STERLING RANCH
 FILING 3
 GENERAL NOTES

STERLING RANCH
FILING 3
STREET IMPROVEMENT PLAN

STERLING RANCH FILING 3
 STORM SEWER PLAN
 SHEET 3 OF 7
 JOB NO. 25188.00

DP-02 PROFILE (2)
STA 7+00.00 TO 10+99.01

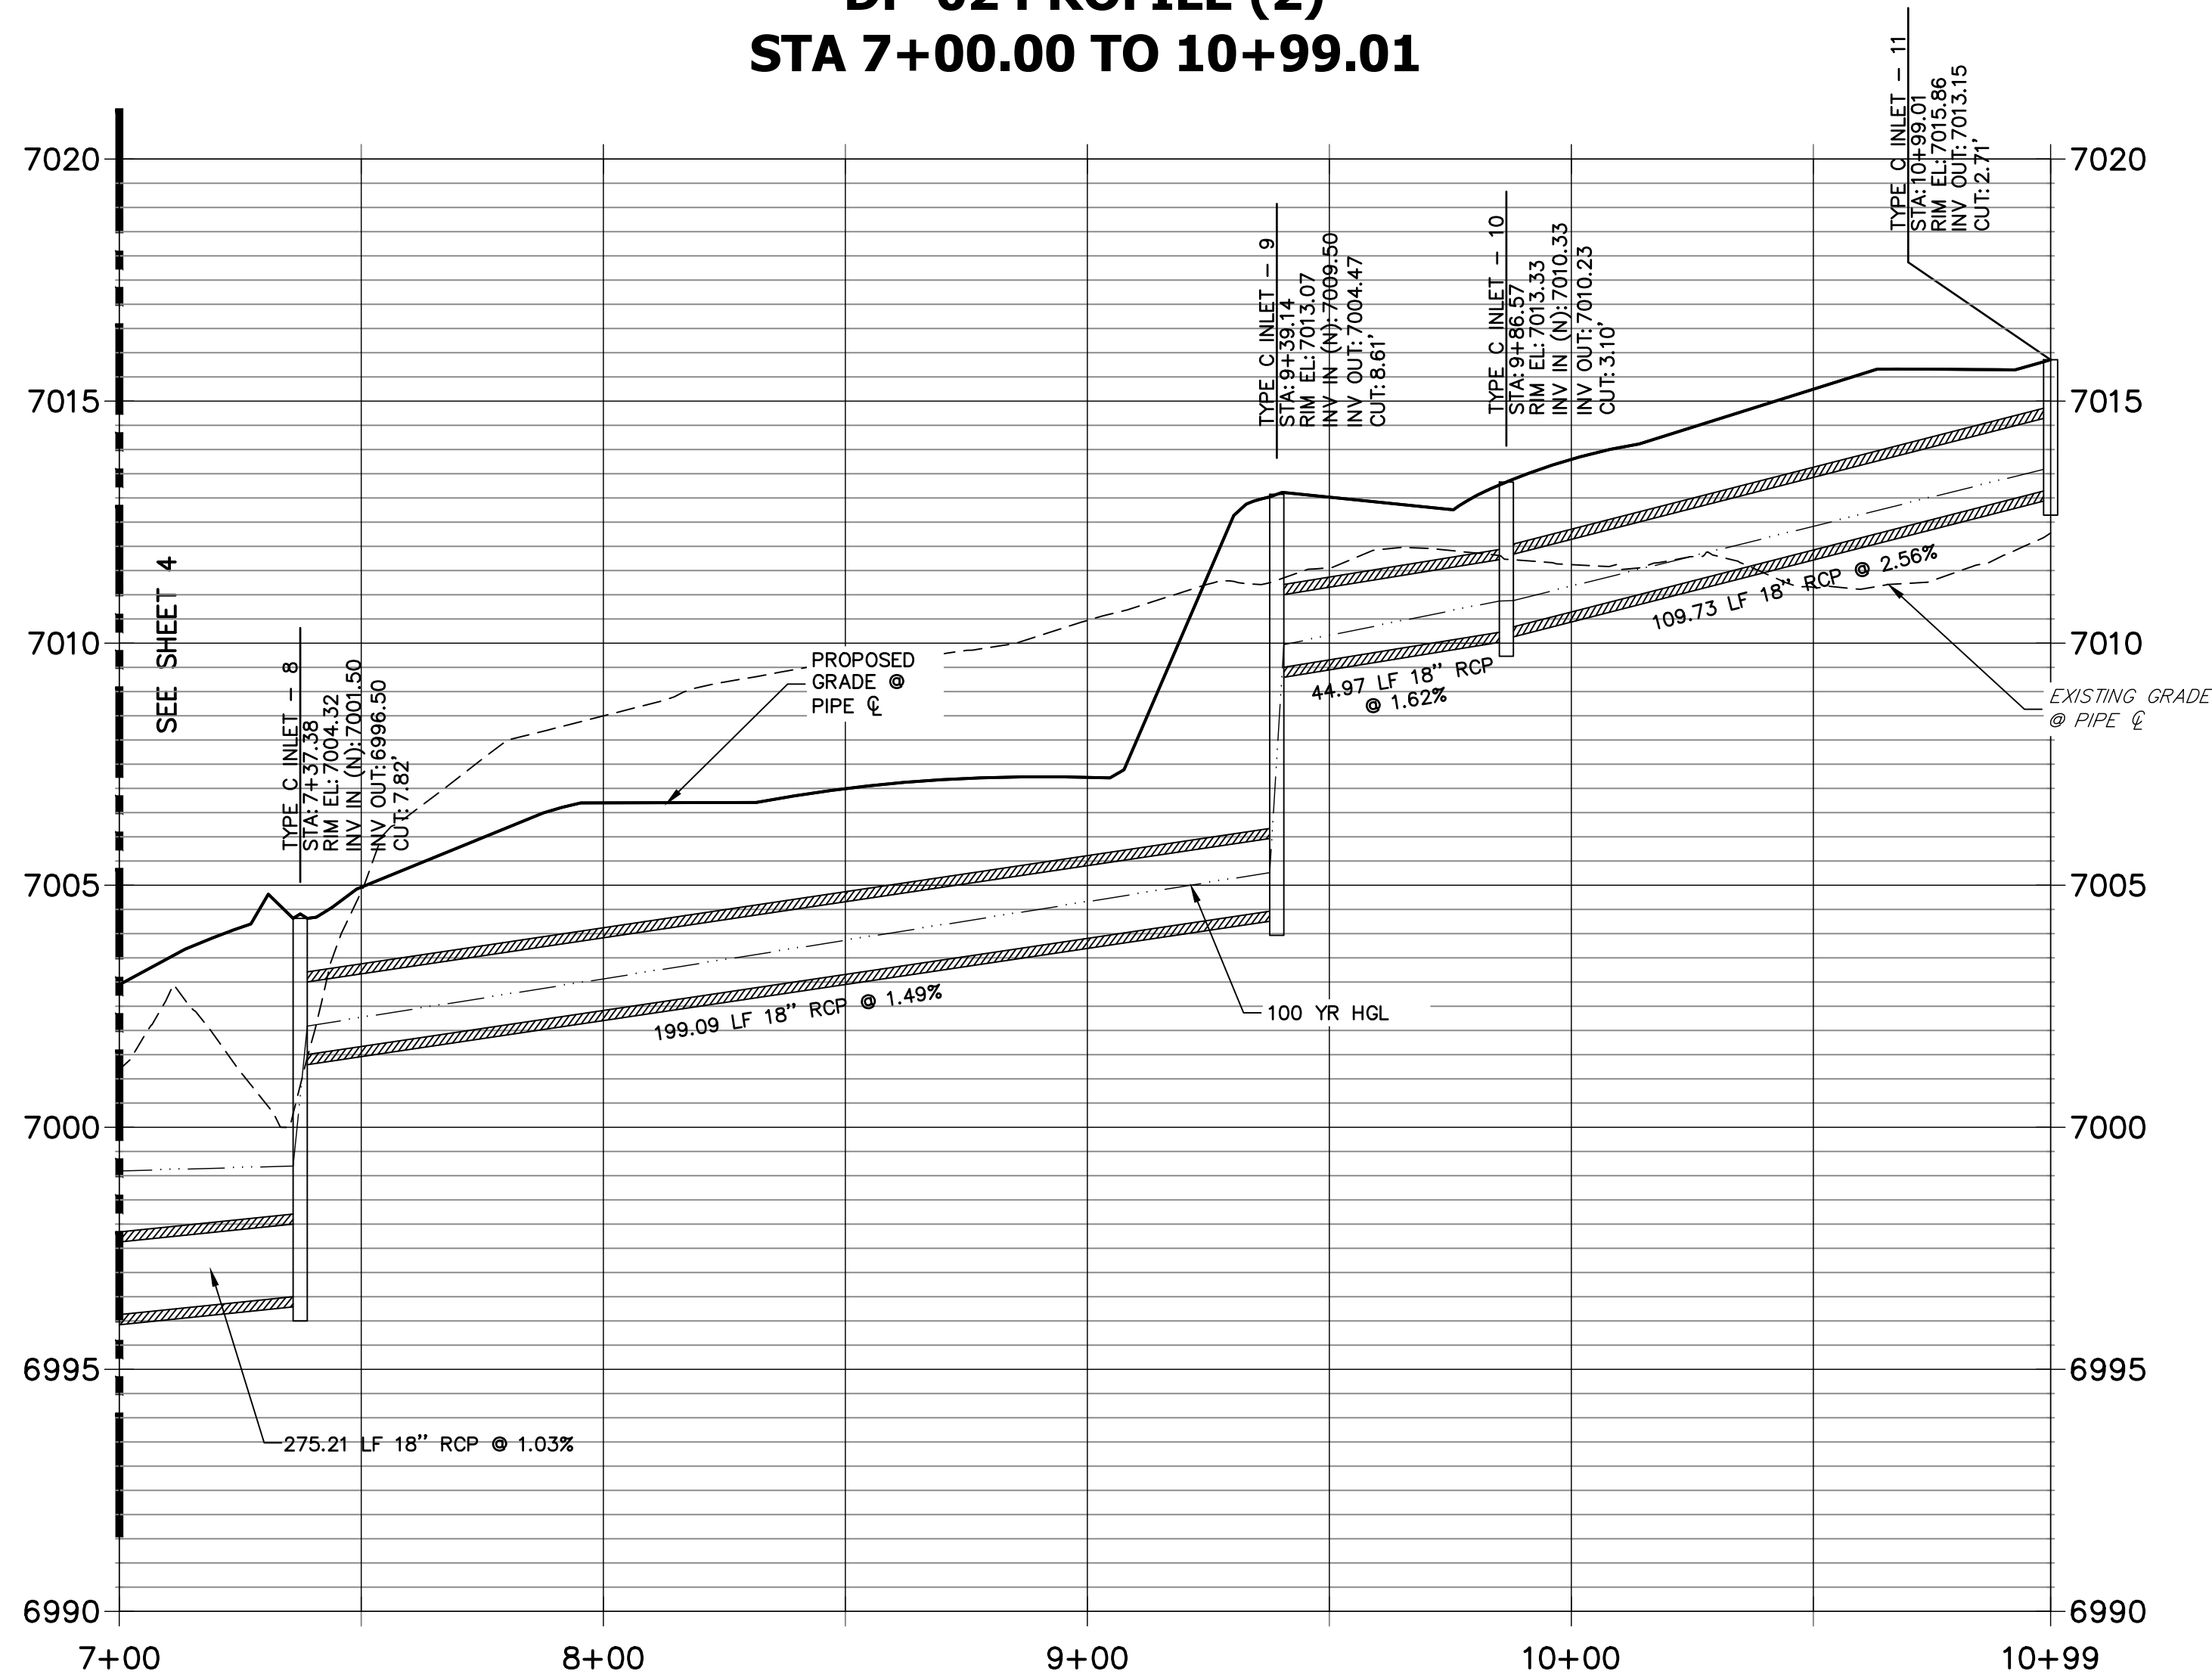
Show and label
the necessary
drainage
easement.
